**RE: Champion Xpress Car Wash
5307 4th Street NW
Grading and Drainage Plan
Engineer's Stamp Date: 05/09/22
Hydrology File: F14D036A**

Based upon the information provided in your submittal received 05/09/2022, the Grading & Drainage Plan **is not** approved for Building Permit and SO19 Permit. The following comments need to be addressed for approval of the above referenced project:

Design: RJM | Proj: 21.262 Draw: MCM Dwg: 21-262.dwg Check: RJM Tab: C3.0-GP Scale: 1" = 20' 06.14.2022 **GRADING PLAN**

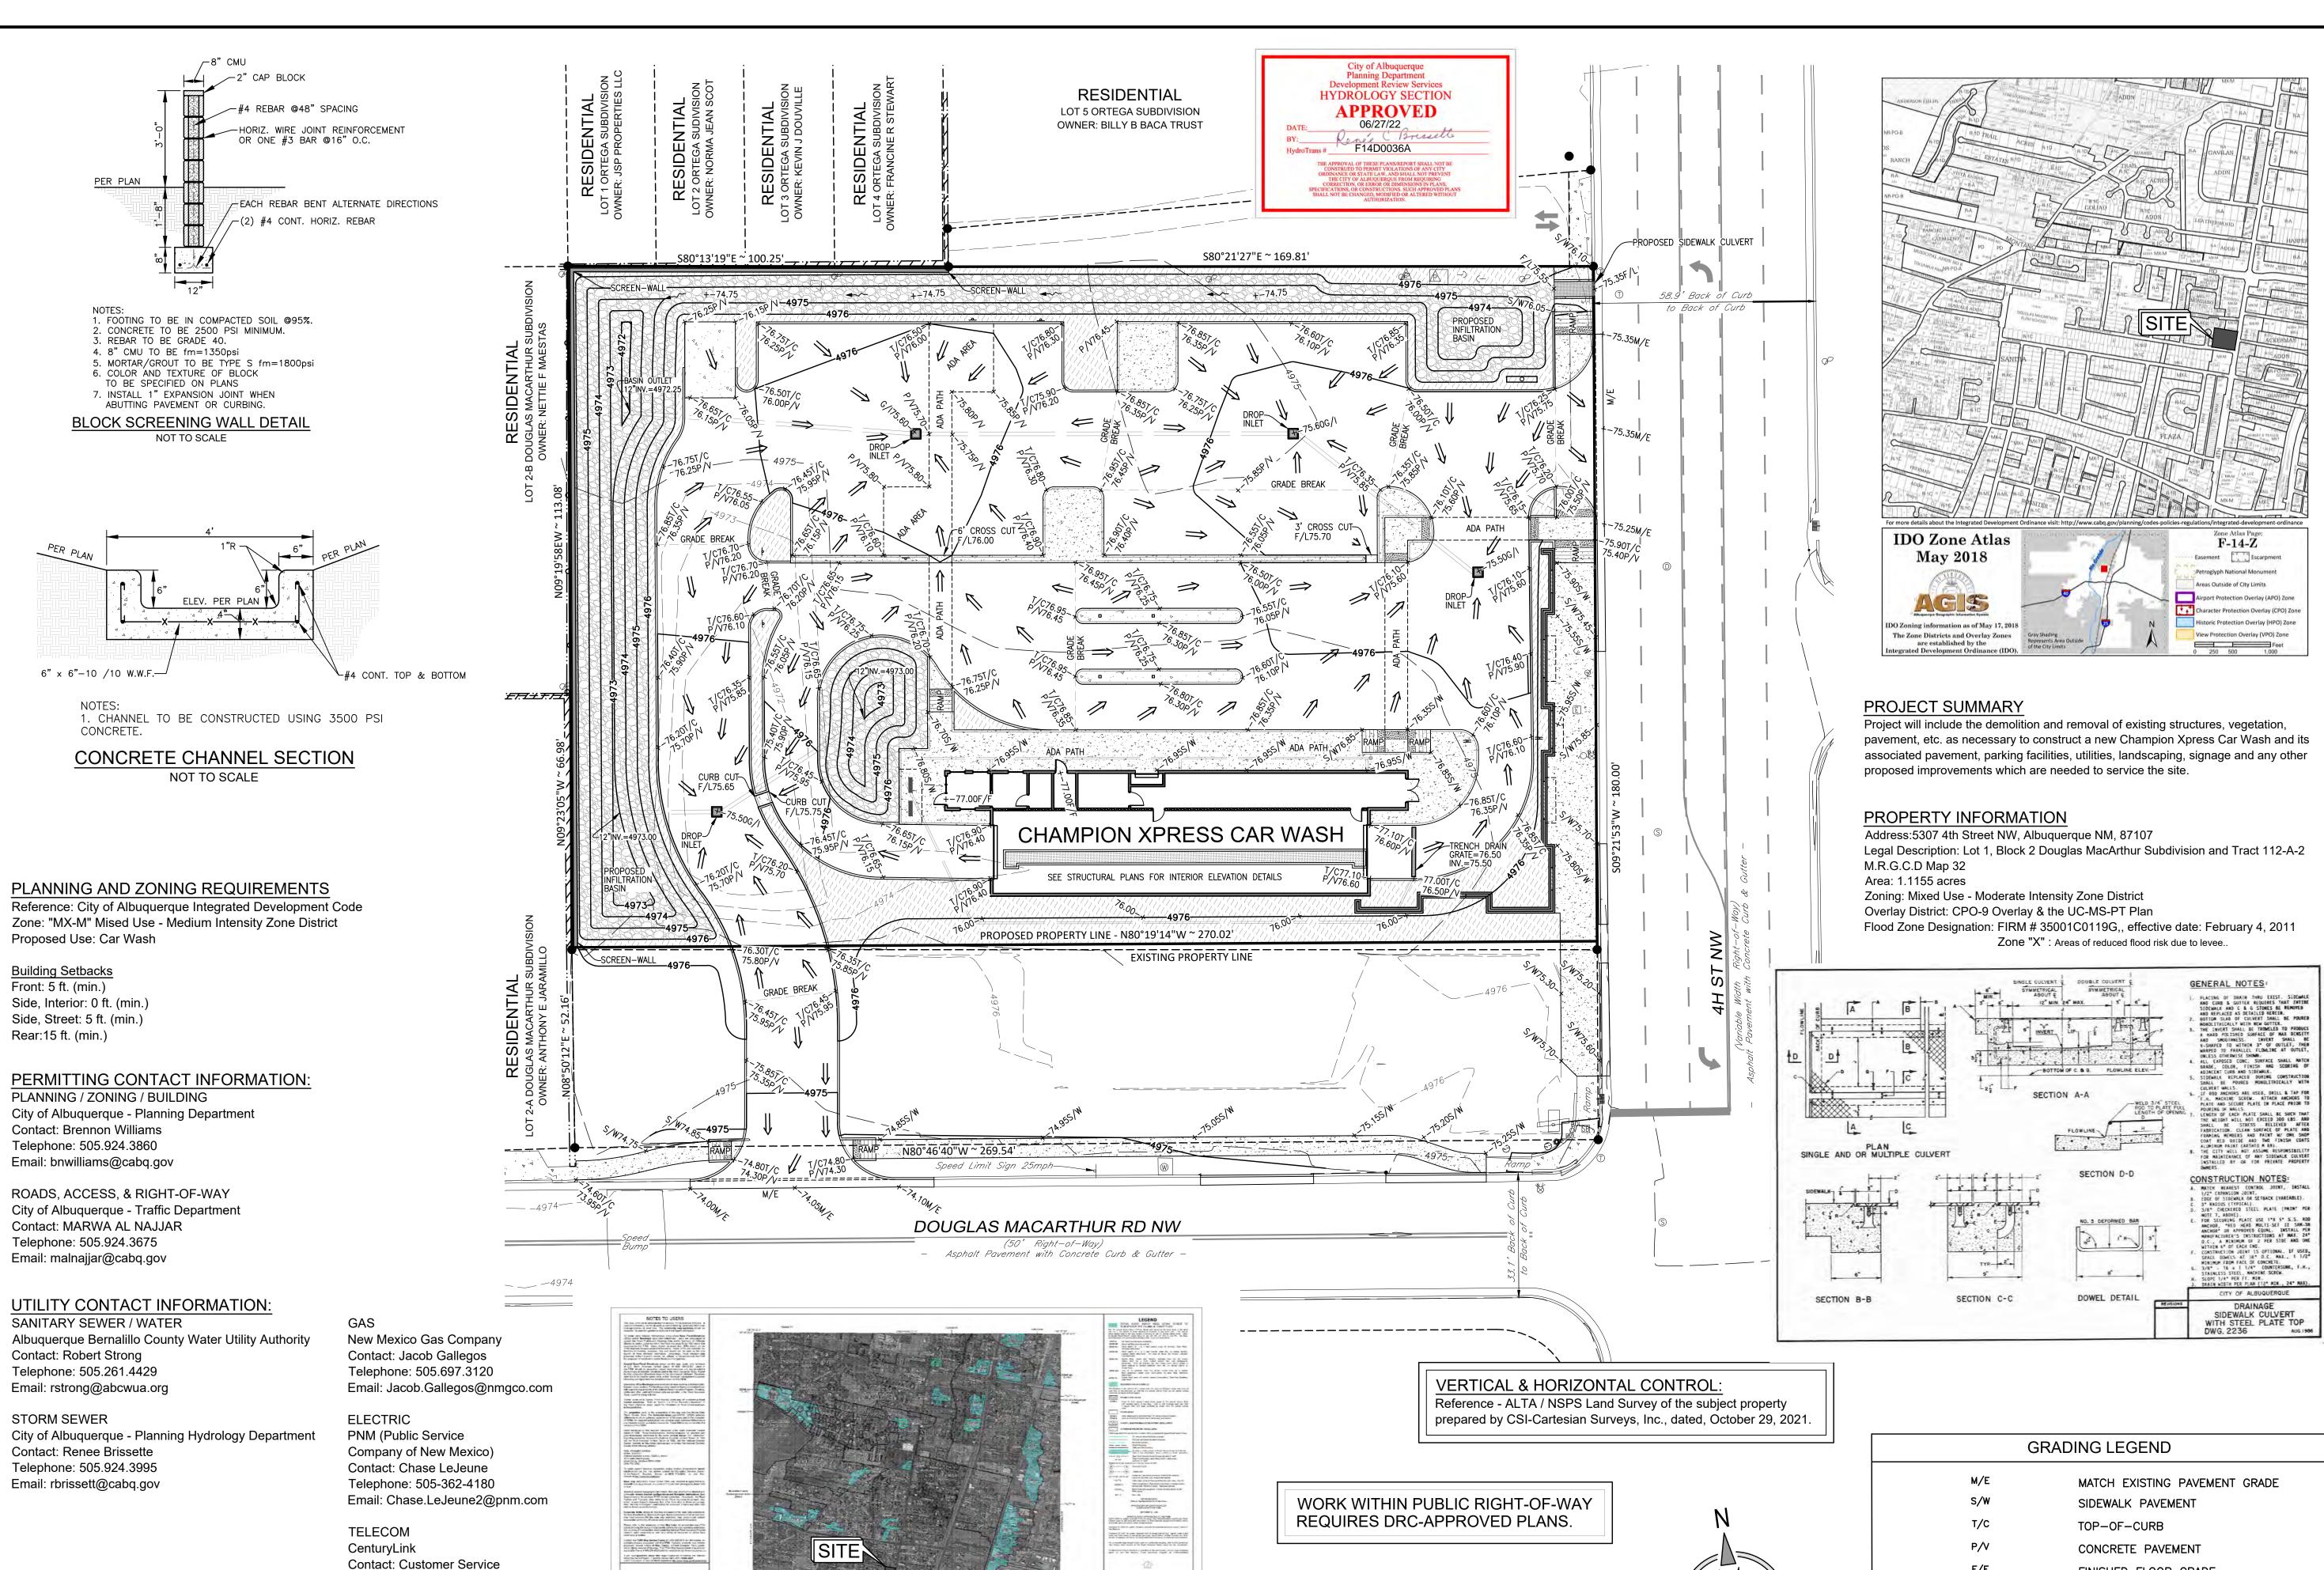
1. The property to the southwest currently has a building, sidewalks and landscaping within Douglas MacArthur Rd R.O.W. None of this existing information is shown and there is shown proposed new sidewalk and an access road through this property.

4. The calculations provided for the management onsite for the Stormwater Quality Volume (SWQV) is incorrect. The calculations used the number for a redevelopment and this site is new development. Therefore, per DPM Article 6-12 Stormwater Quality and Low-Impact Development for the sizing calculations. To calculate the required SWQV, multiply the impervious area draining to the BMP by 0.42 inches for new development sites.

5. Please provide the weir calculations, per DPM Article 6-16(A), for the curb cuts and sidewalk culverts. A coefficient of 2.7 is typically used for the weir equation $Q = CLH^{2/3}$.

6. Please show all storm pipe sizing, inlet grate elevations and inverts on the Grading & Drainage Plan.
7. The shown drainage area appears to not get discharged into a stormwater quality pond prior to leaving the property. This cannot directly discharge into the City's storm drain system without doing so. This site has lots of landscape areas to provide the required SWQV.

8. A possible solution to Comment #7 is to direct the inlet to the landscape area and enlarge the stormwater quality pond. Also, the outlet for the pond can be a sidewalk culvert on 4th Street.
